Our Case Number: ACP-323060-25

Re: Mayo County Council Ballina Flood Relief Scheme Compulsory Purchase Order No 1 of 2025
River Moy, County Mayo

Ballina Flood Relief Scheme
Case reference: CH16. 323060

T74 AS SHOWN ON: - MGW0290-RPS-00-XX-DR-D-WL007-05

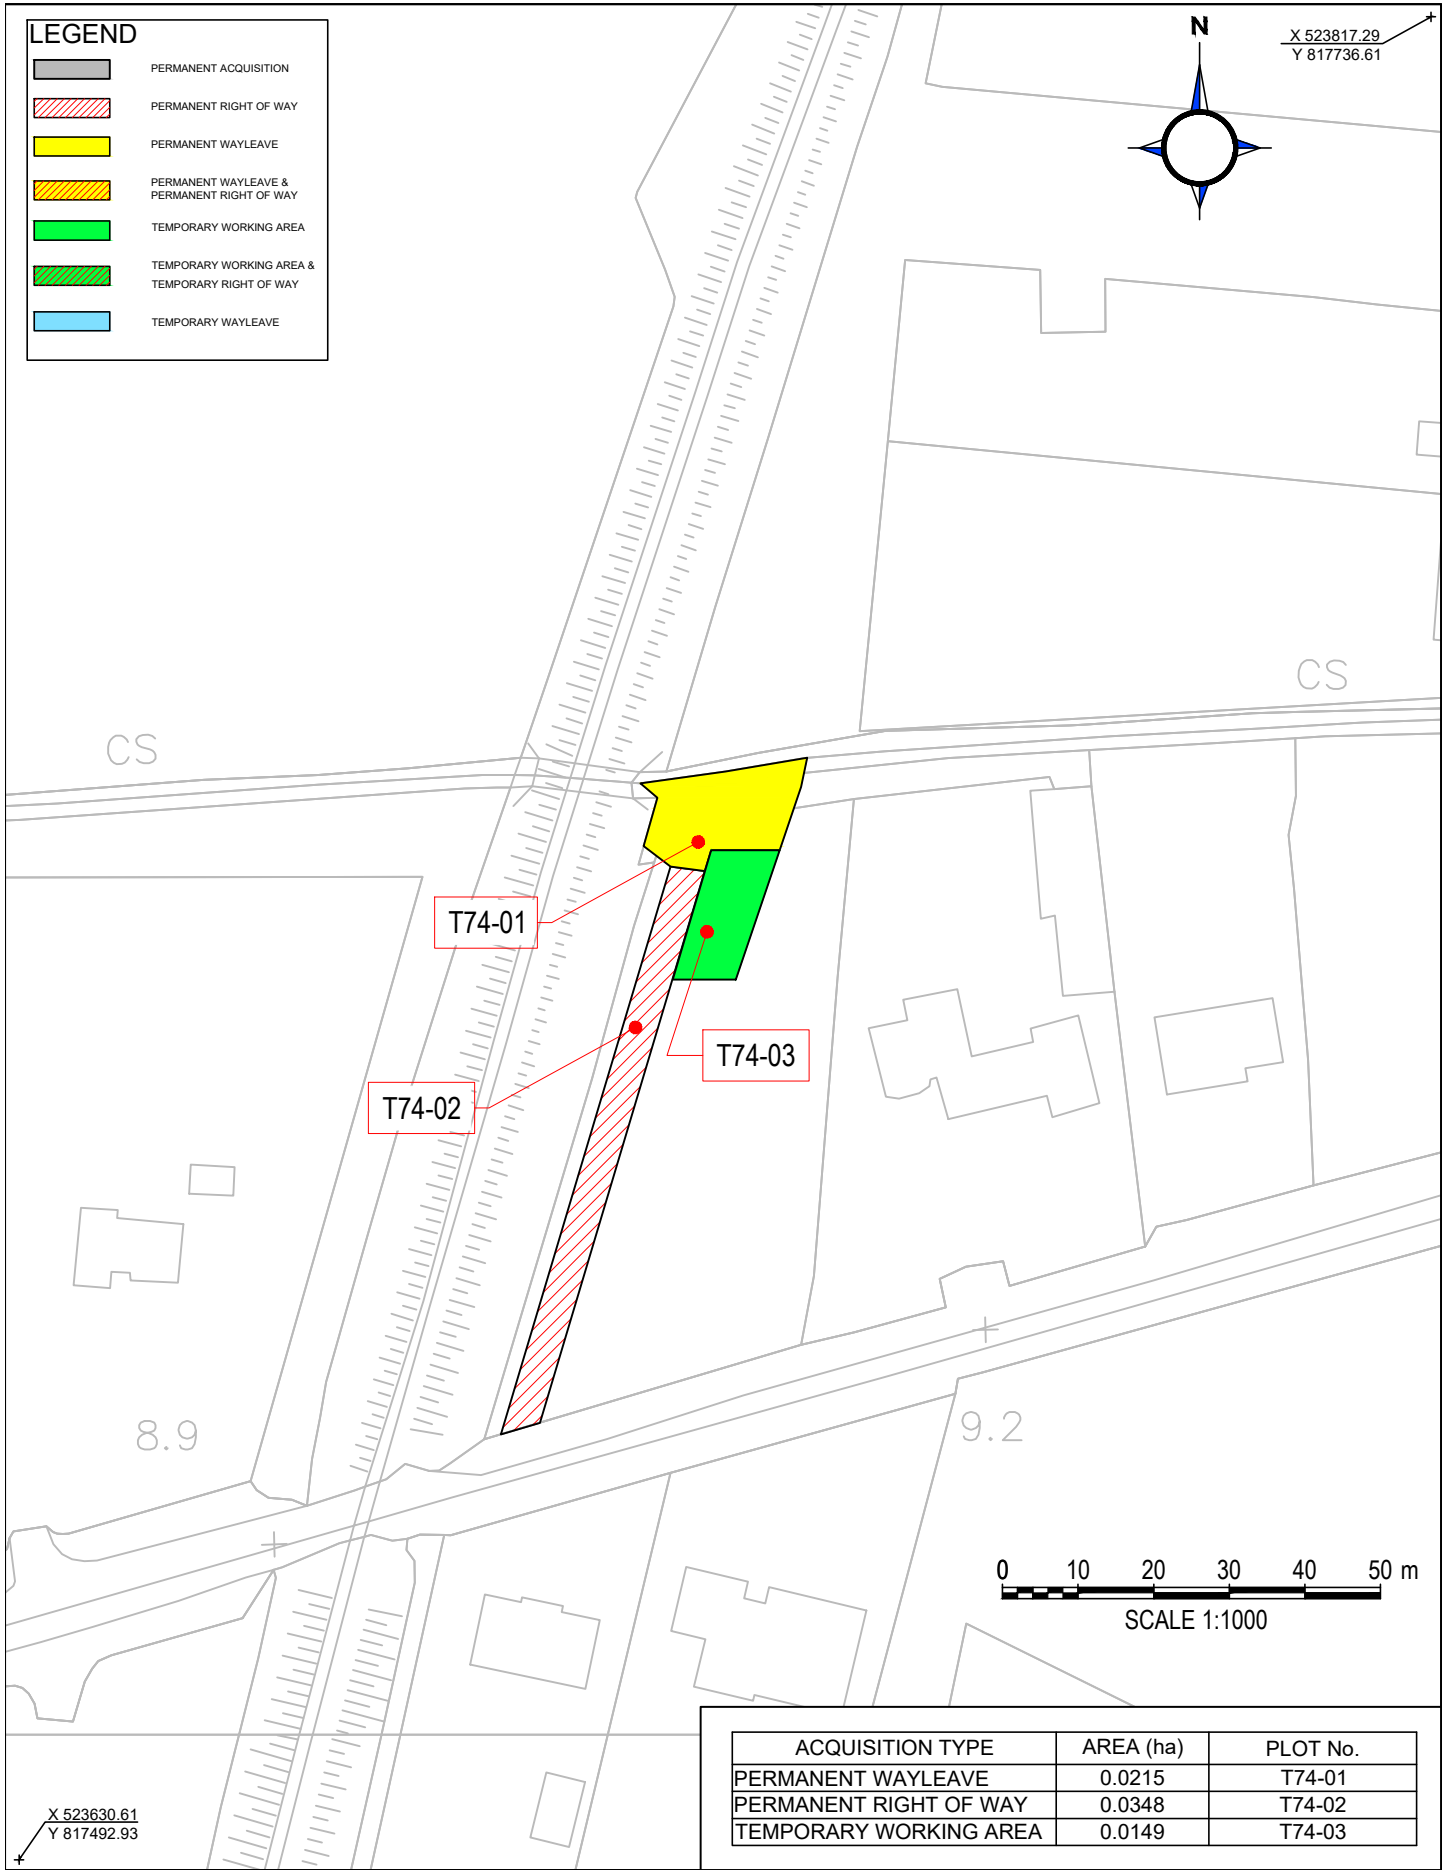
From the outset I wish to highlight that the CPO references (refs.) T74-01, T74-02 and T74-03) addressed to an unknown landowner / reputed landowner / plot occupier, form part of my residence.

The Local Authority is seeking permanent wayleaves (refs. T70-03 & T74-01), temporary working areas (refs. T74-03 & T70-01) and a permanent right of way (ref. T74-02) amounting to a total of 1,253sq.m of my residential property. This would have inexplicable impact on the enjoyment of this property by myself and my family, including loss of private amenity space, loss of privacy and extensive change to the appearance of the area.

There is an existing flood wall running along the northern boundary of my property, and the subject proposals would merely duplicate this in an unnecessary, unsustainable manner. Proposals that had been submitted with the flood risk assessment do not clearly set out the intention for the entire area of my property subject of the CPO notice. In short, I am unclear as to how my property would be treated, including landscaping, boundaries and services, and why my property is to be acquired.

- the extent of area required is excessive and exorbitant relative to the identified flood design levels, including freeboard, the existing flood prevention measures and the associated works intended as part of the flood relief scheme in this area, including a flood wall measuring 0.86m in depth along the northern boundary of my property – subsurface works are noted but these do not necessitate the permanent loss of property;
